CITY OF ALBUQUERQUE

May 20, 2016

**Re: Trapnell Orthodontics
Los Volcanos Rd NW
Grading and Drainage Plan
Engineers Stamp Date 2/11/15 (J09D022)**

M:\PROJECTS\2000-2099\2053DWG2053 CG-101.dwg, 11/25/2014 3:44:41 PM, Plot

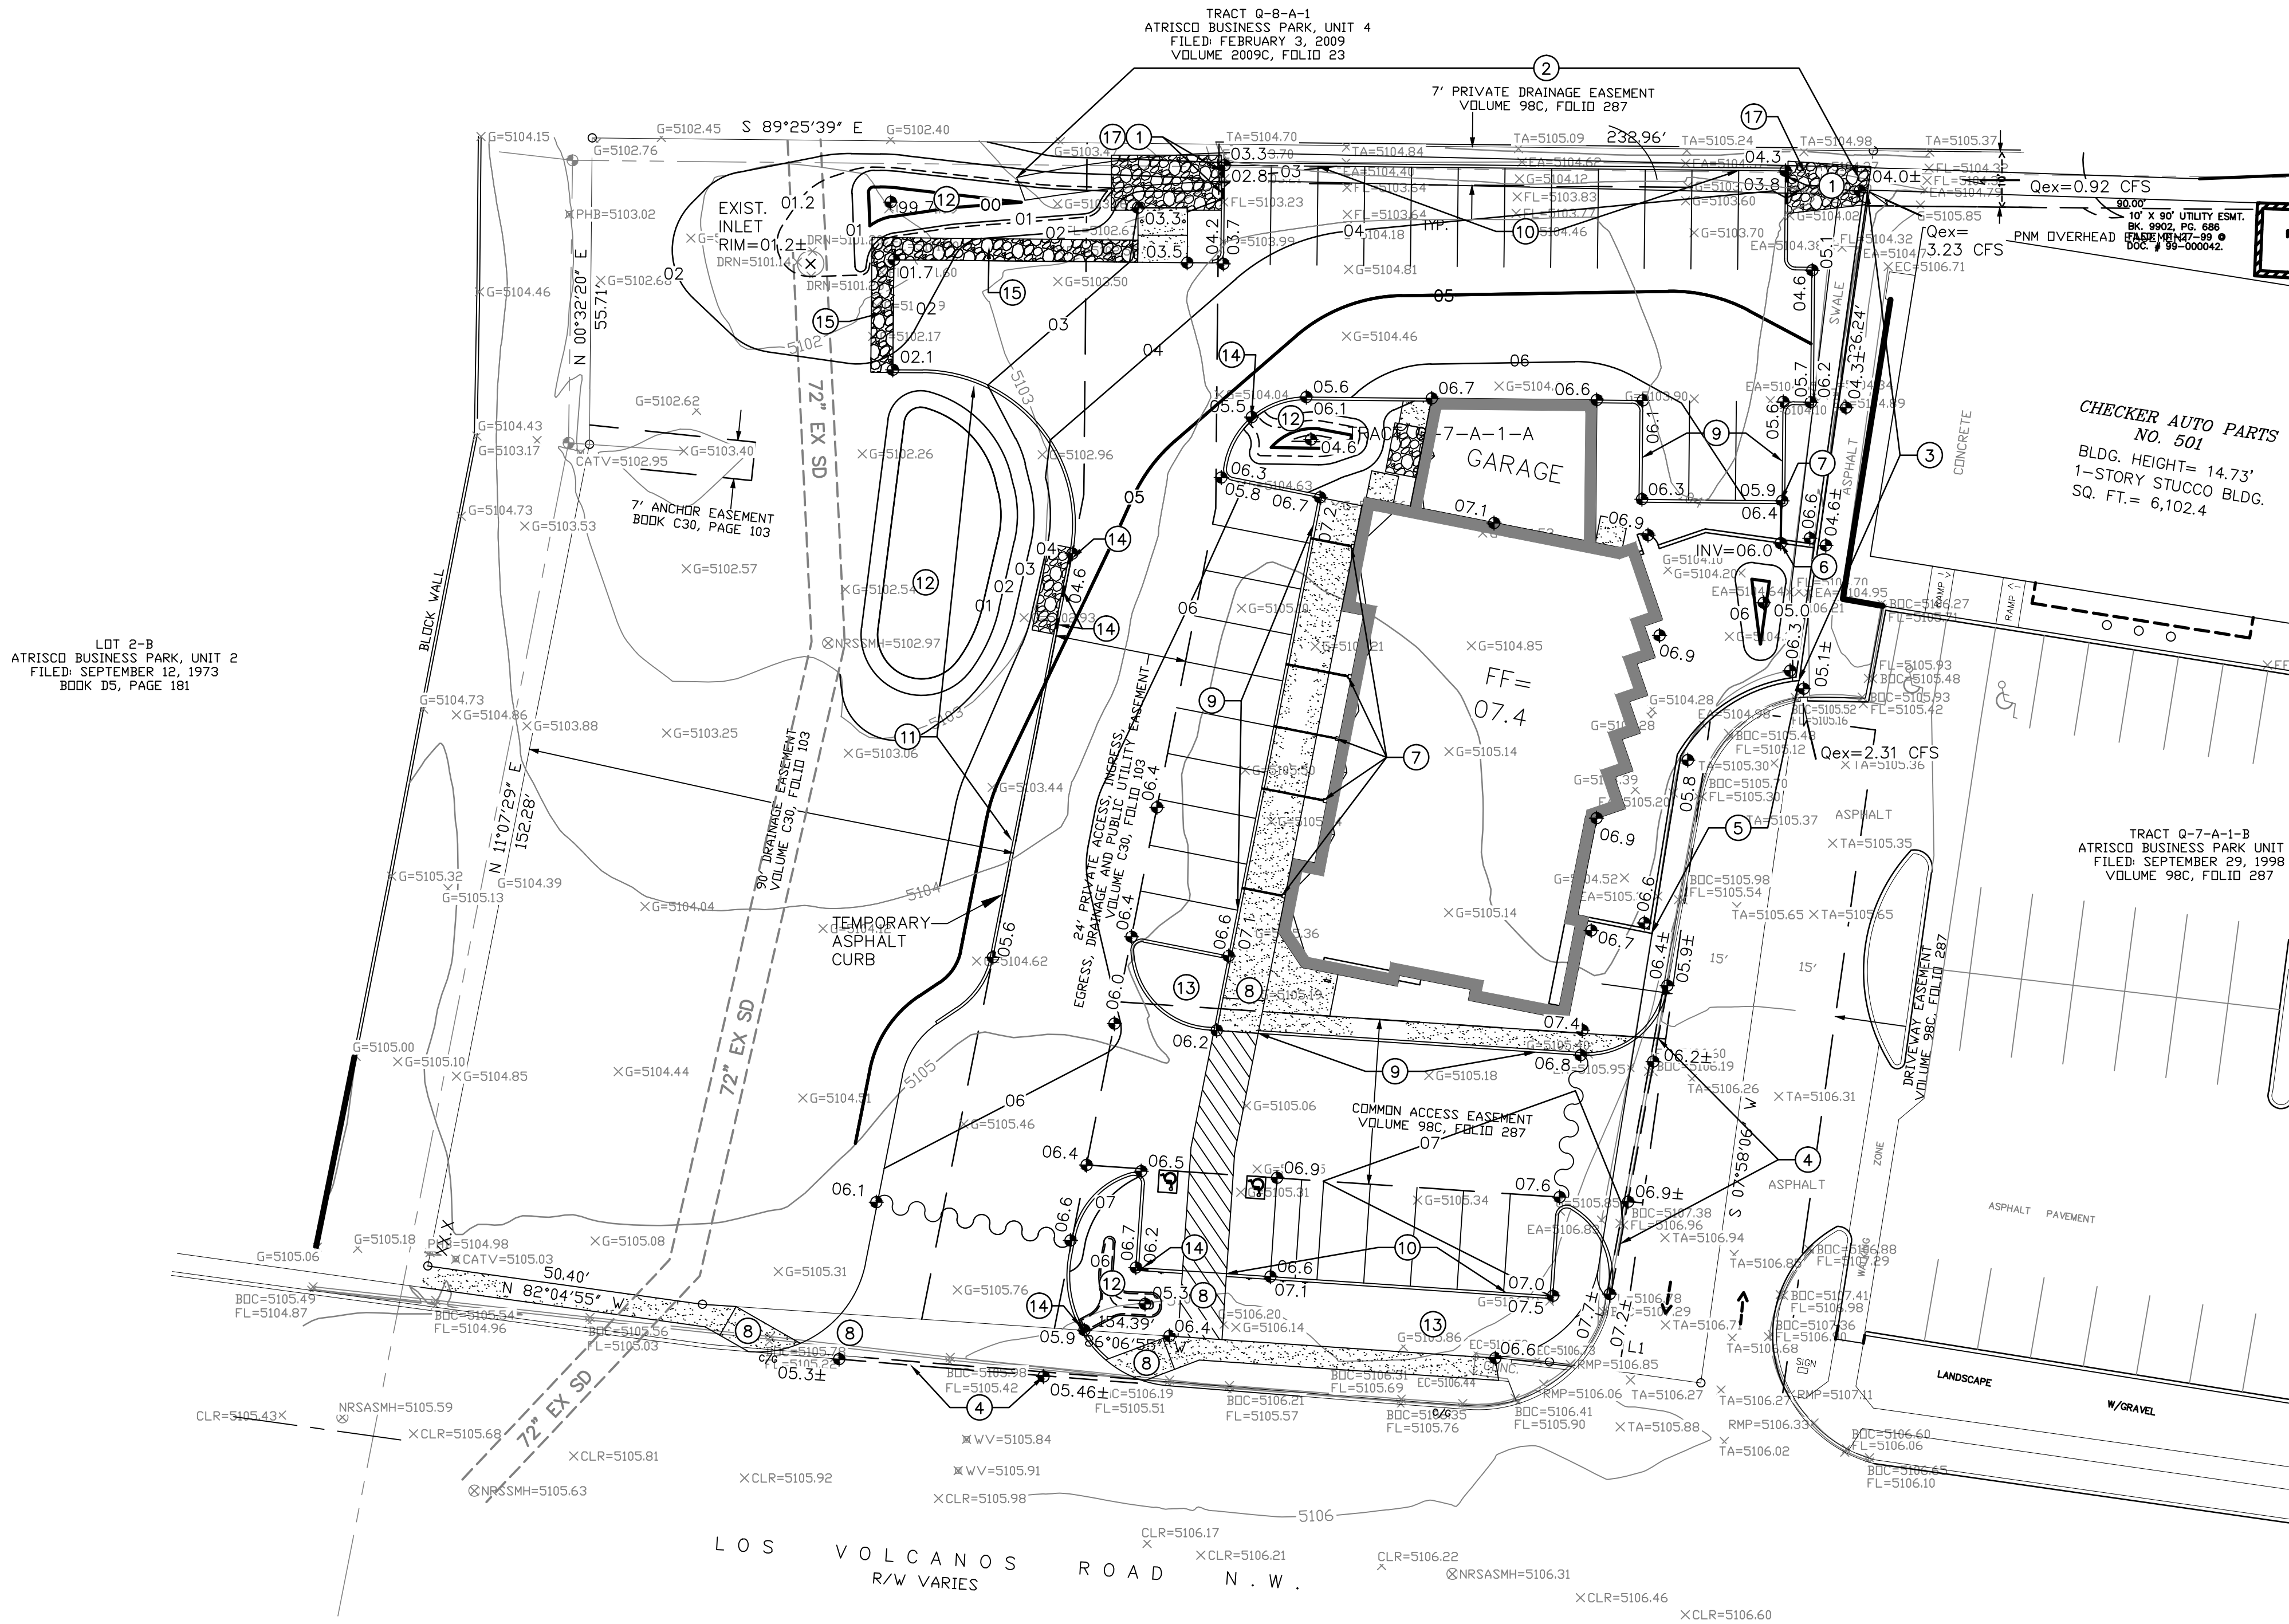
1. Provide the allowable amount of discharge into the on-site storm drain for this site as described in the Clifford West Business Park. Also include the amount for the Checker Auto site since the flows from that site are going through the Trapnell property. Show that the actual discharge is less than allowable amount and the pond is sized appropriately.

1 COURTYARD WALL DRAIN  
PER KEYED NOTE #6 NTS

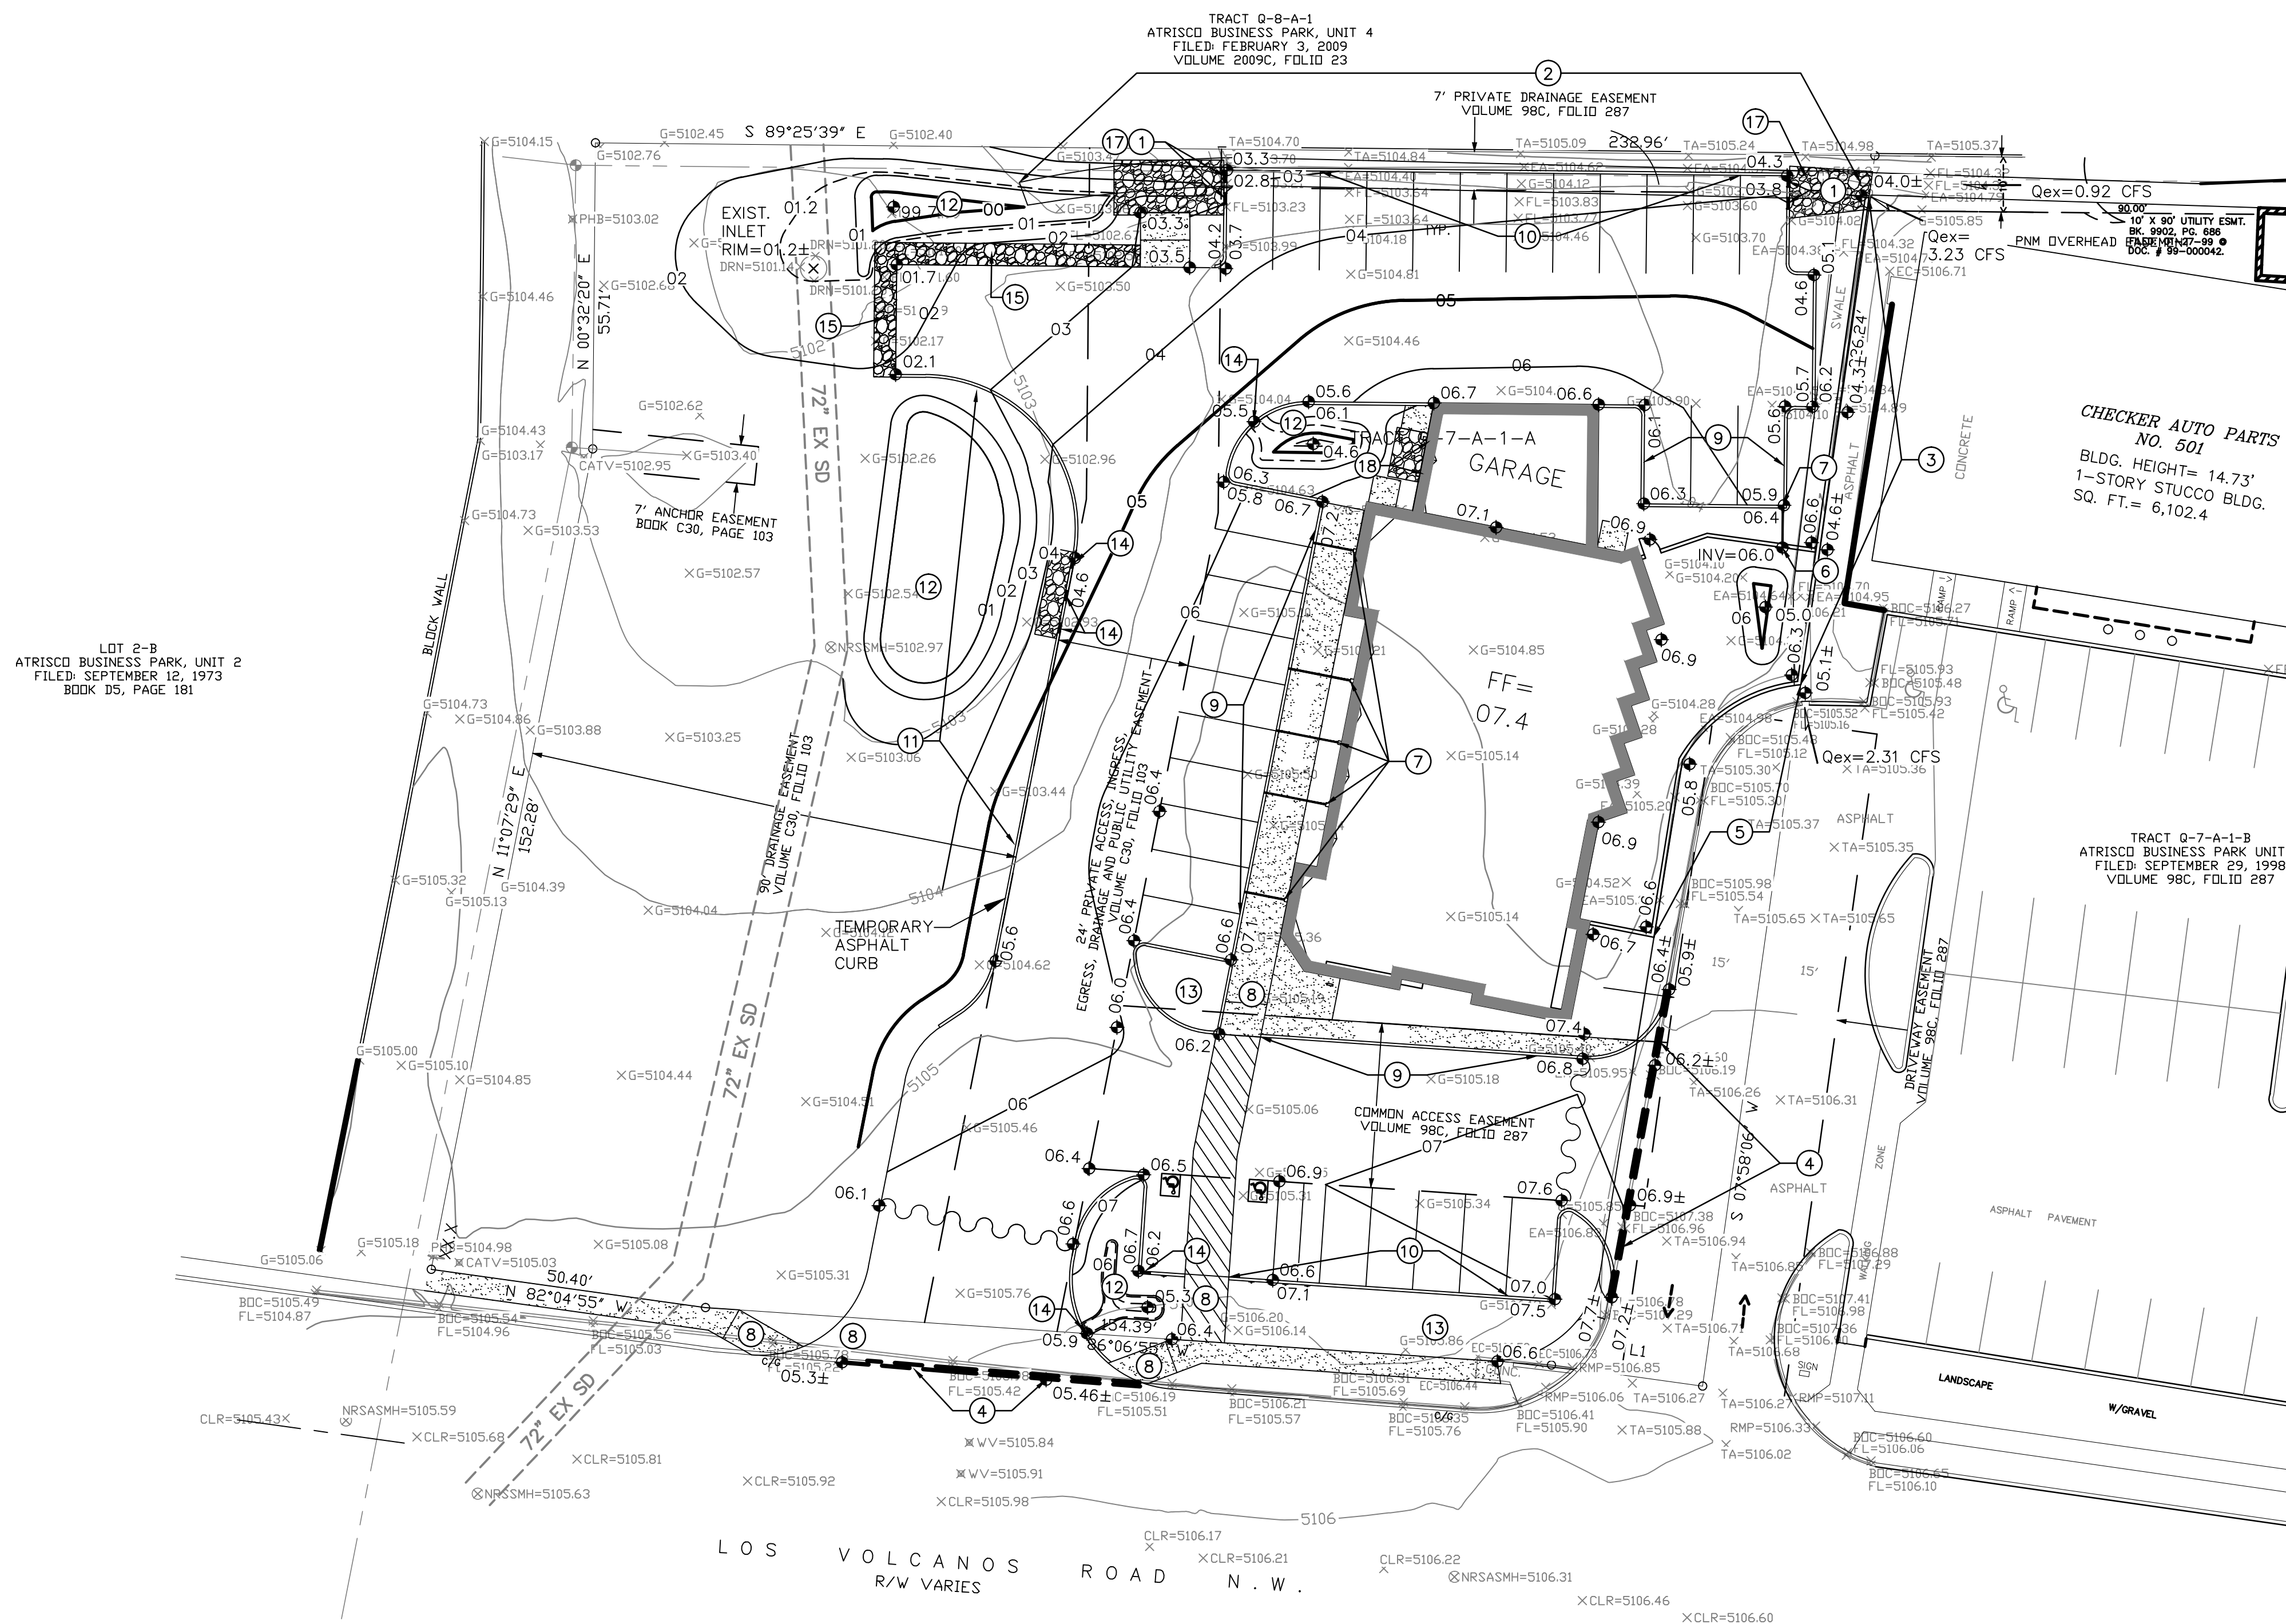
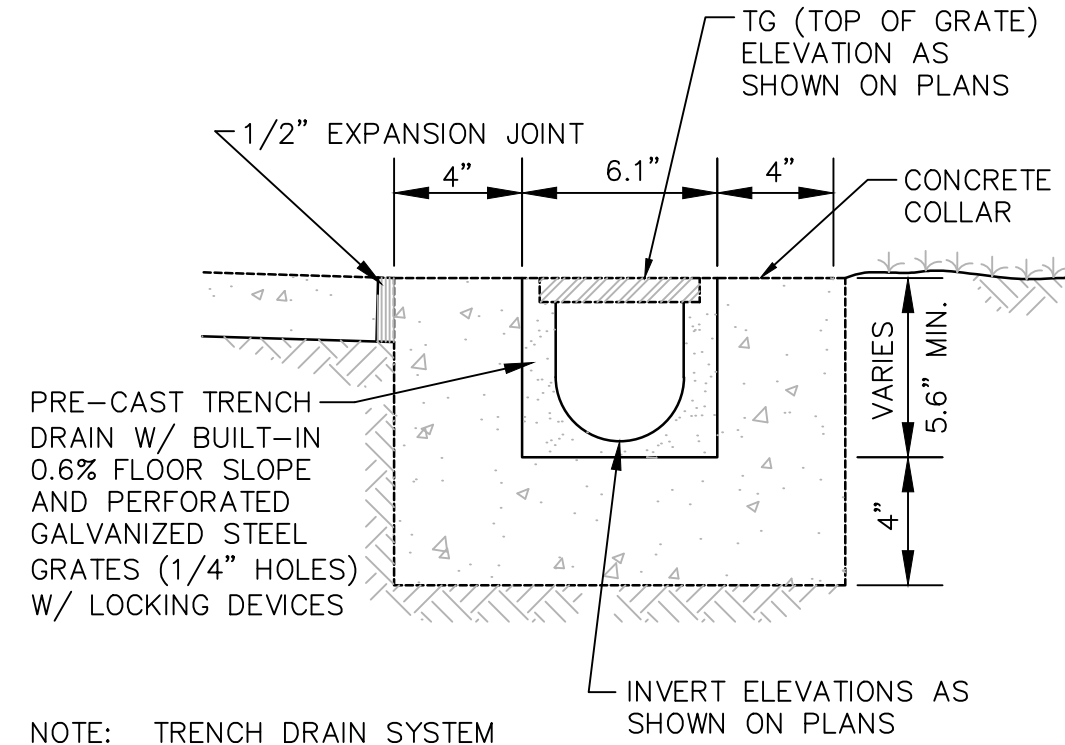
I visited the site this AM and I have one question. Note #5 states that the retaining wall is to have vertical gaps along the row of blocks at the top earth grade. These openings are missing. Will the site drain sufficiently without these openings?

I hadn't thought to look at those. Good catch. Because of the final landscaping in the courtyard and the fact that it's only water that falls in the courtyard that affects the ponding back there, I don't think it'll be a problem for flooding of the building.

Holes to relieve hydrostatic pressure behind retaining walls are always a good idea, though. I'll ask the contractor to put a few 4" PVC pipes through the wall.
